KITITITAS COUNTY

MEMORANDUM

TO: Jeremy Johnston, Planner - Kittitas County CDS
FROM: Justin Turnbull, County Surveyor *ST*
DATE: January 11, 2019
SUBJECT: Bowers Field Binding Site Plan Application

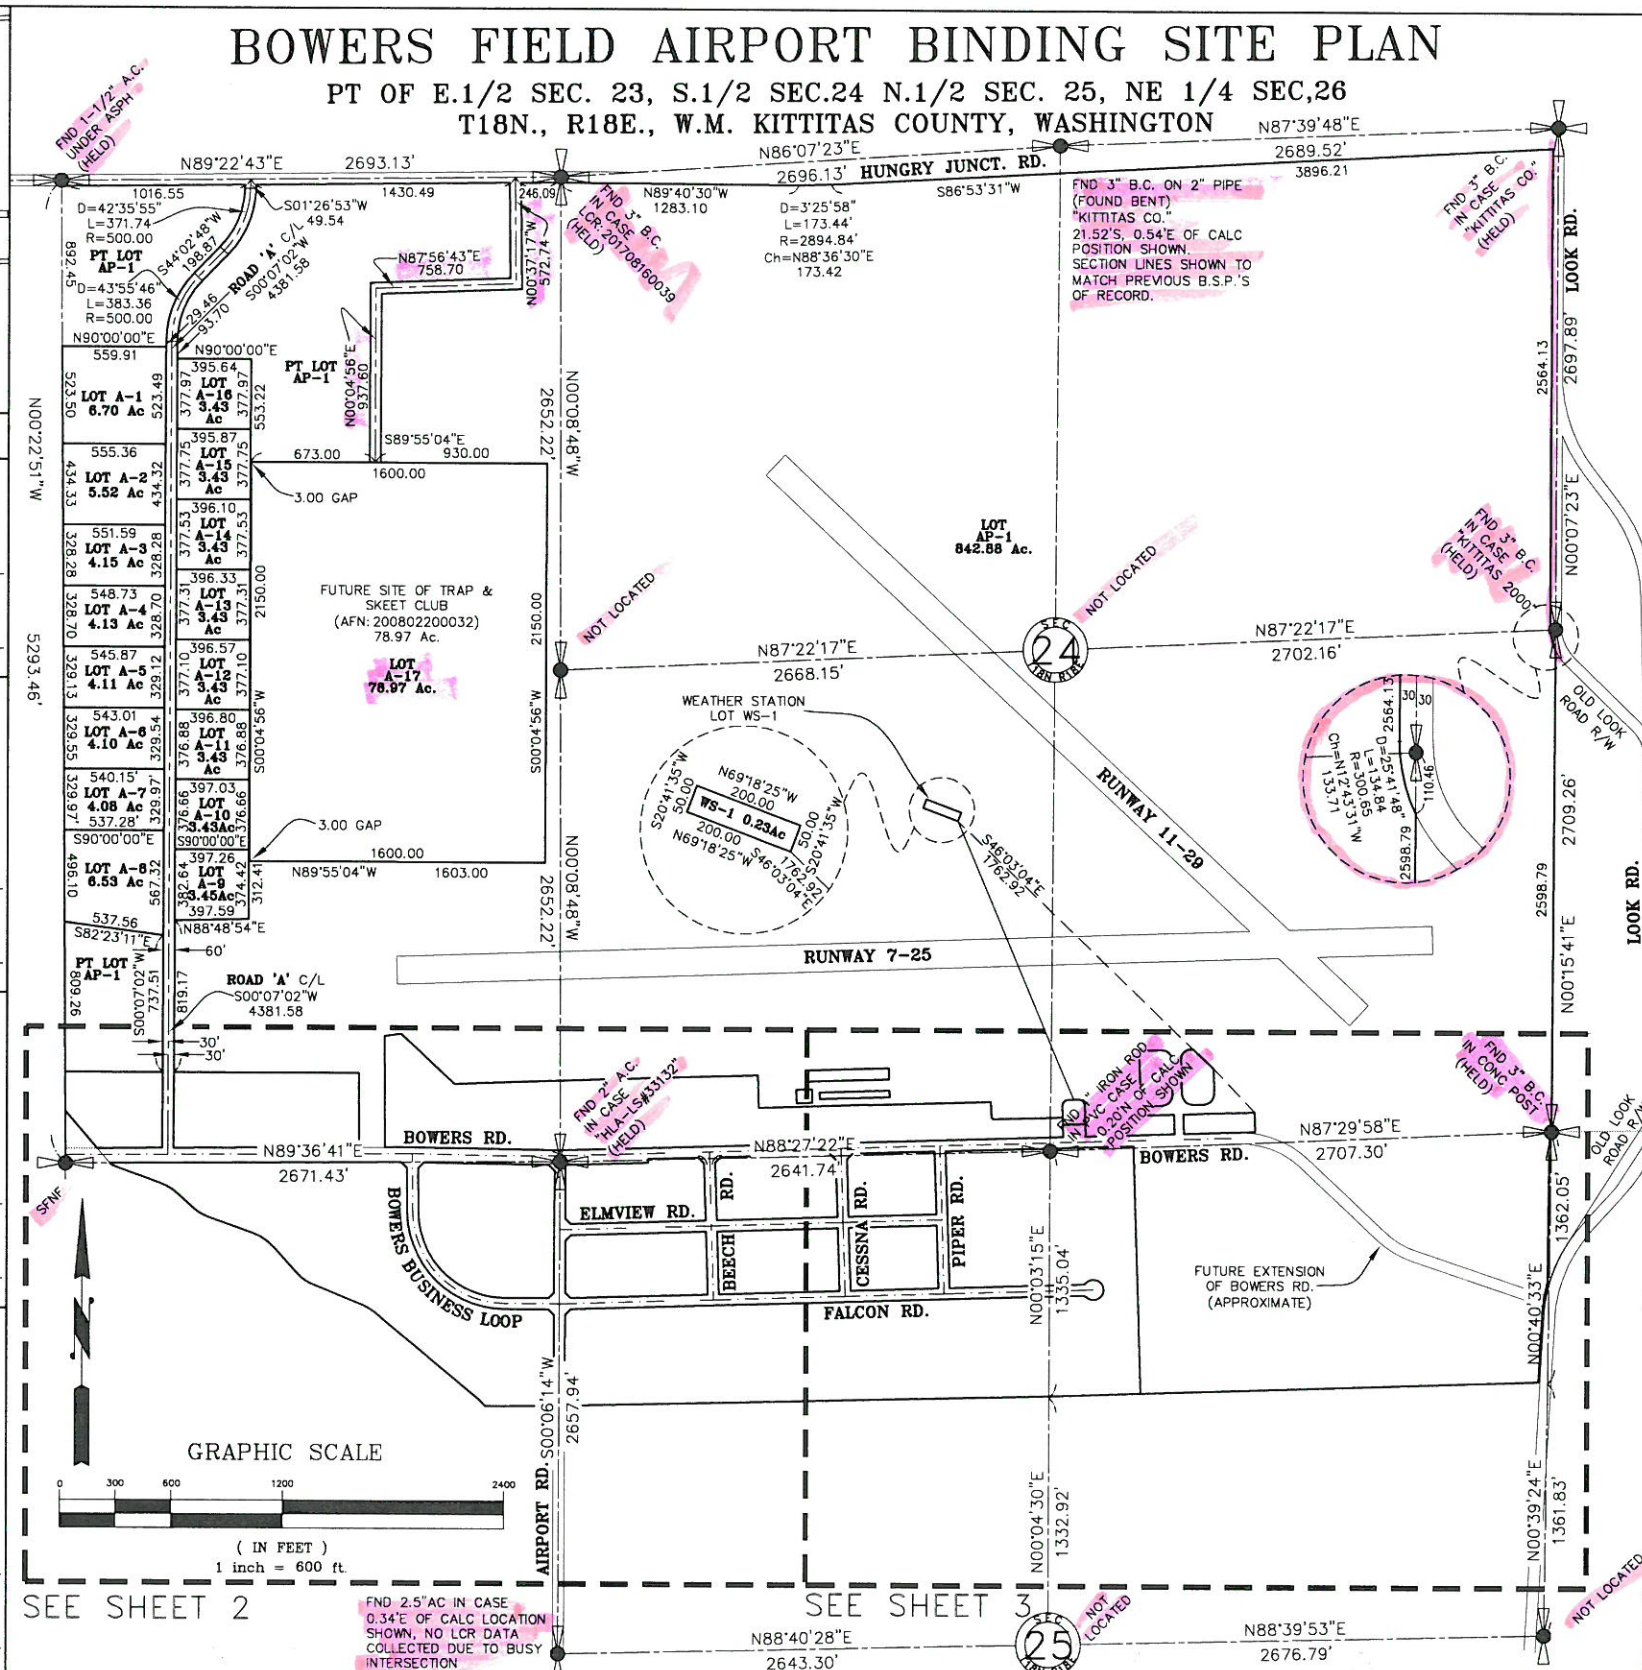
Exterior Airport Boundary

The 2010 BSP never actually surveyed the boundaries, nor the section lines, nor did they properly locate the Road Right of ways. Also the large parcel containing the runway was never assigned a Lot Number. These are reflected in the new site plan.

Lots Beginning with 'A'

Included absent information, as well as gave a lot number to the parcel identified as "Future Trap and Skeet Club" in 2010 BSP.

Tax Parcel 18-19-30020-0002

This is a 10' wide parcel adjacent to the South Boundary of the airport. The 2010 BSP was unclear in this manner.

Lots C-1A, C-1B, C-1C

Created new lots at the request of the lease holder of Lot C-1A.

SHEET	2
OF	3
SHEETS	
PROJECT	17019

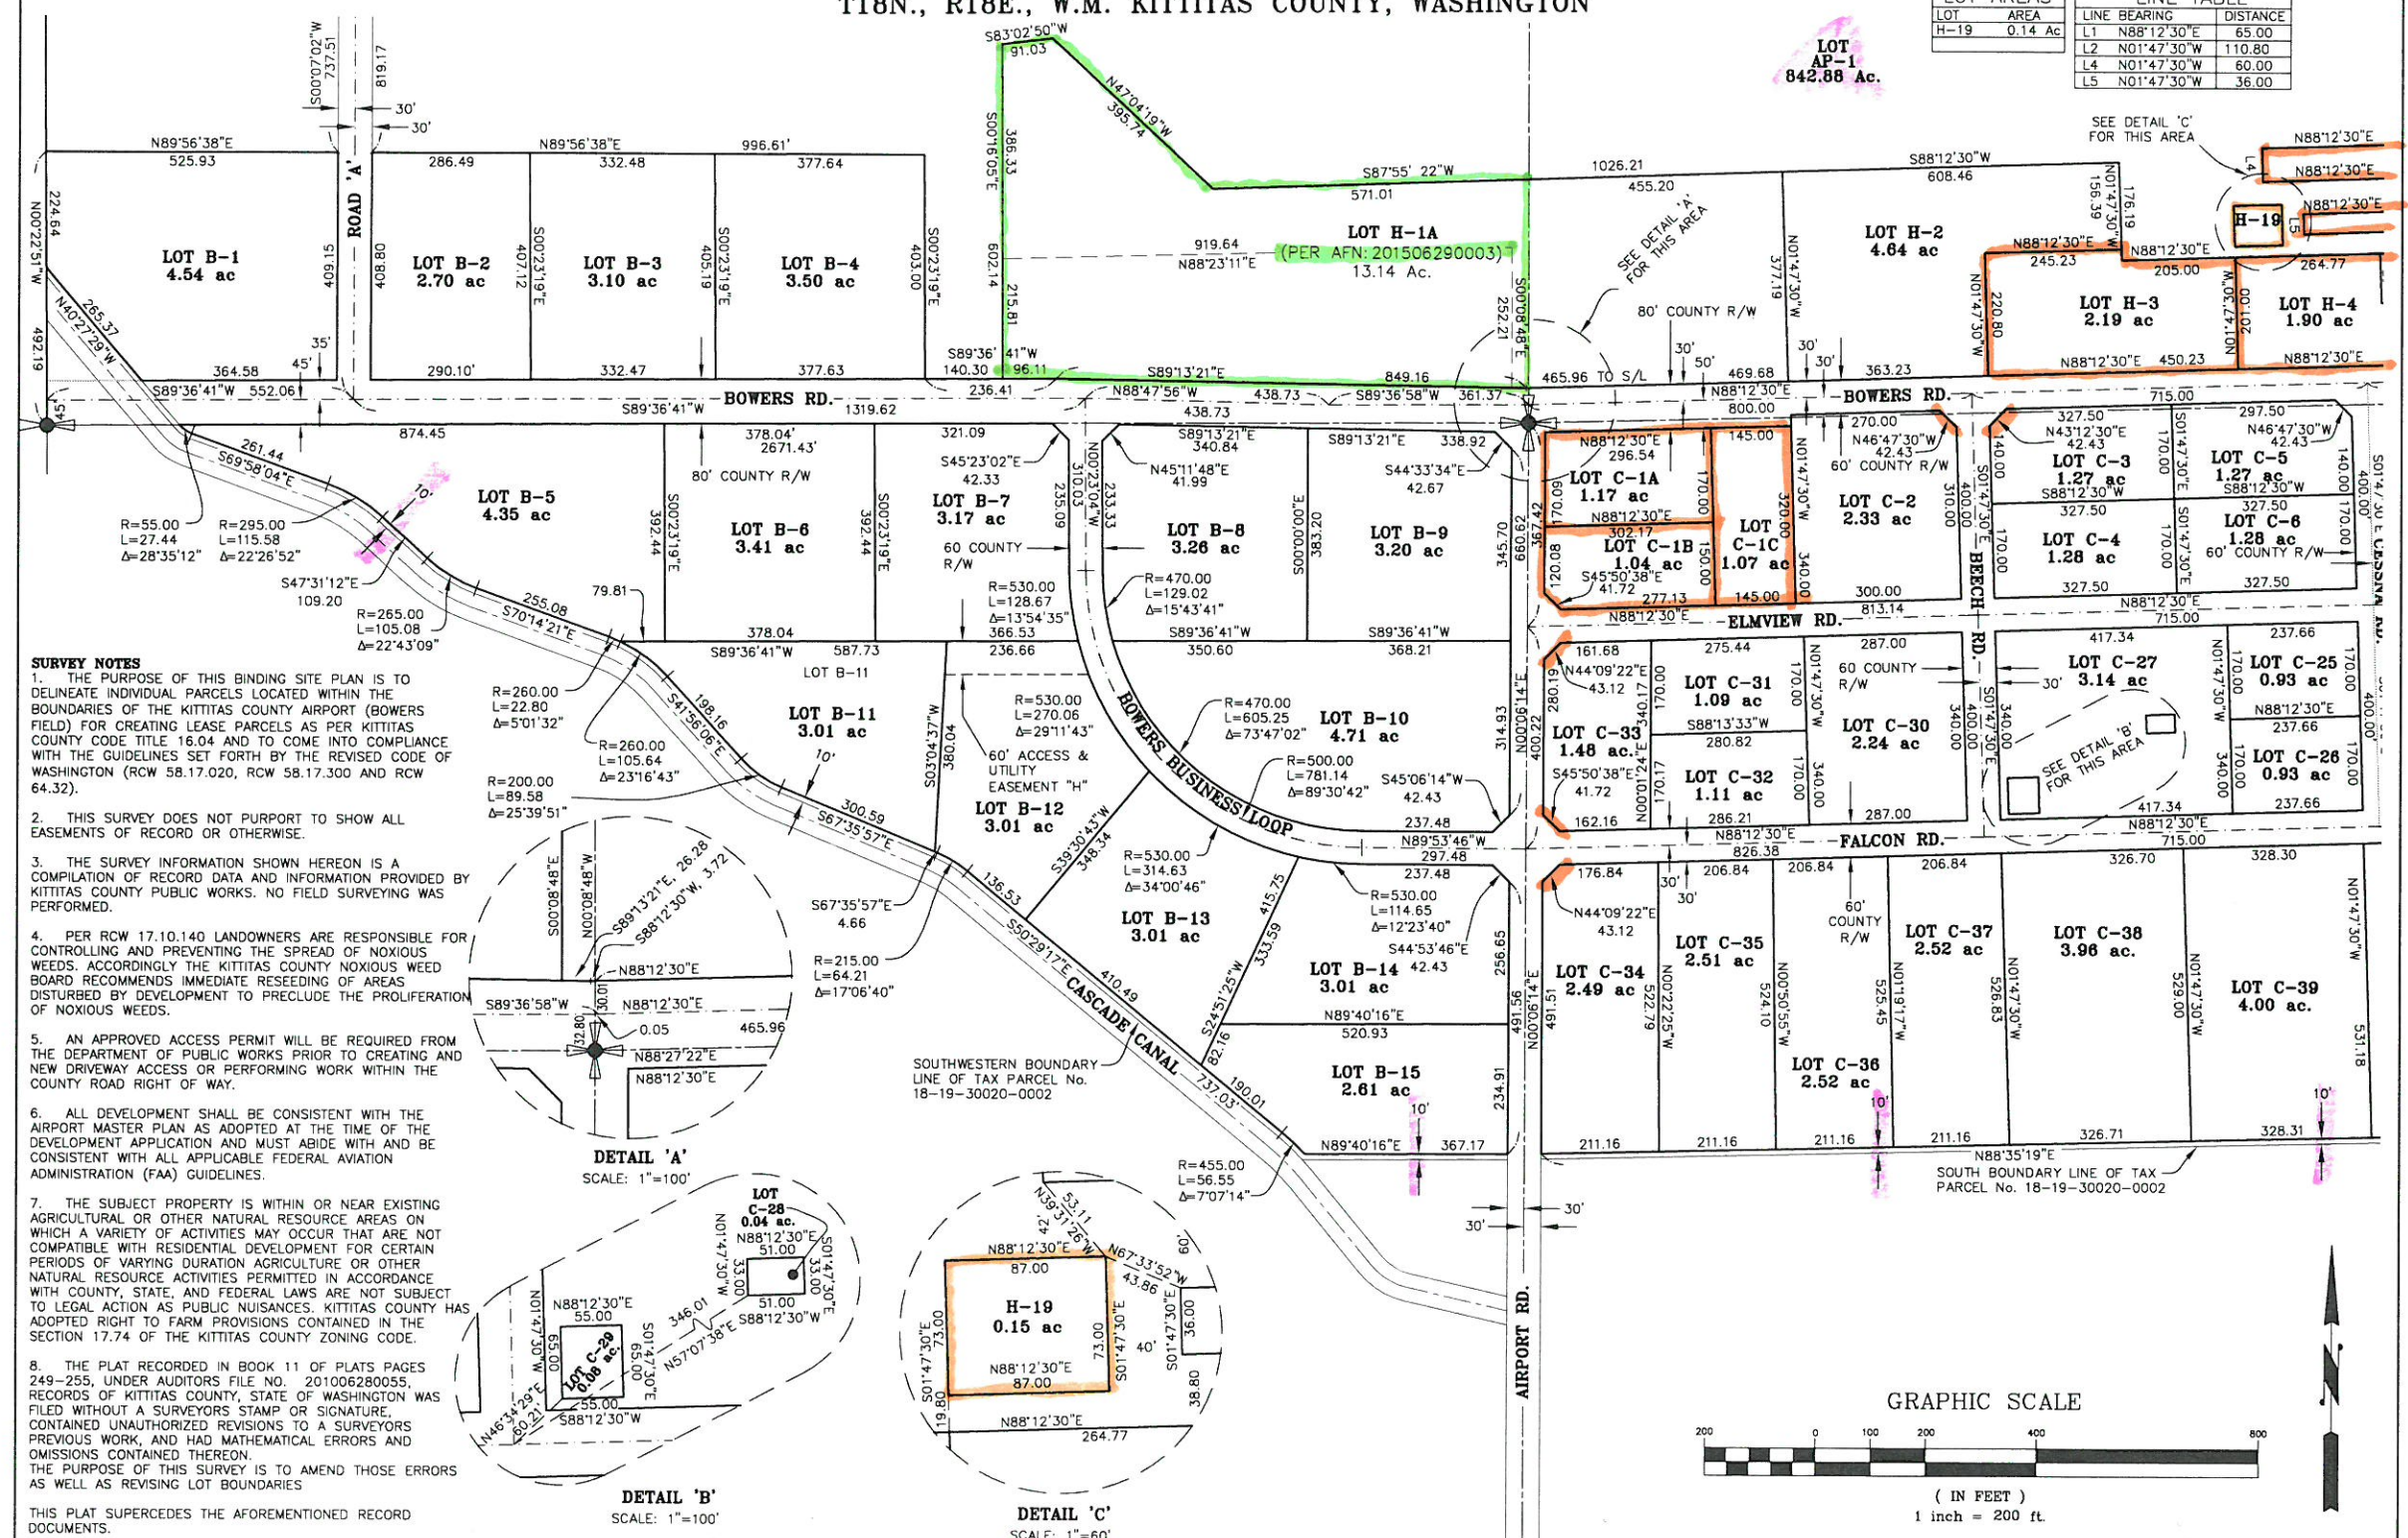
Lots C-33, C-34, C-2, C-3, C-5, C-7

Changed Lot Lines to reflect curb radiuses falling outside existing right of way

Lots H-19, H-20, H-20A

Minor corrections to create a parallel parcel, and /or fit the existing building entirely within the Lot.

Lots H14, H-15, H-16, H-22, H-23, H24

Radiused corners to reflect existing asphalt of Airport Taxiway, Changed layout to reflect future use of airport leases to support larger aircraft.

Lots H-5 to H-13

Revised Lot layout to allow for larger aircraft.

Lots H3, H4

Revised Lots to allow for predicted business or agency use.
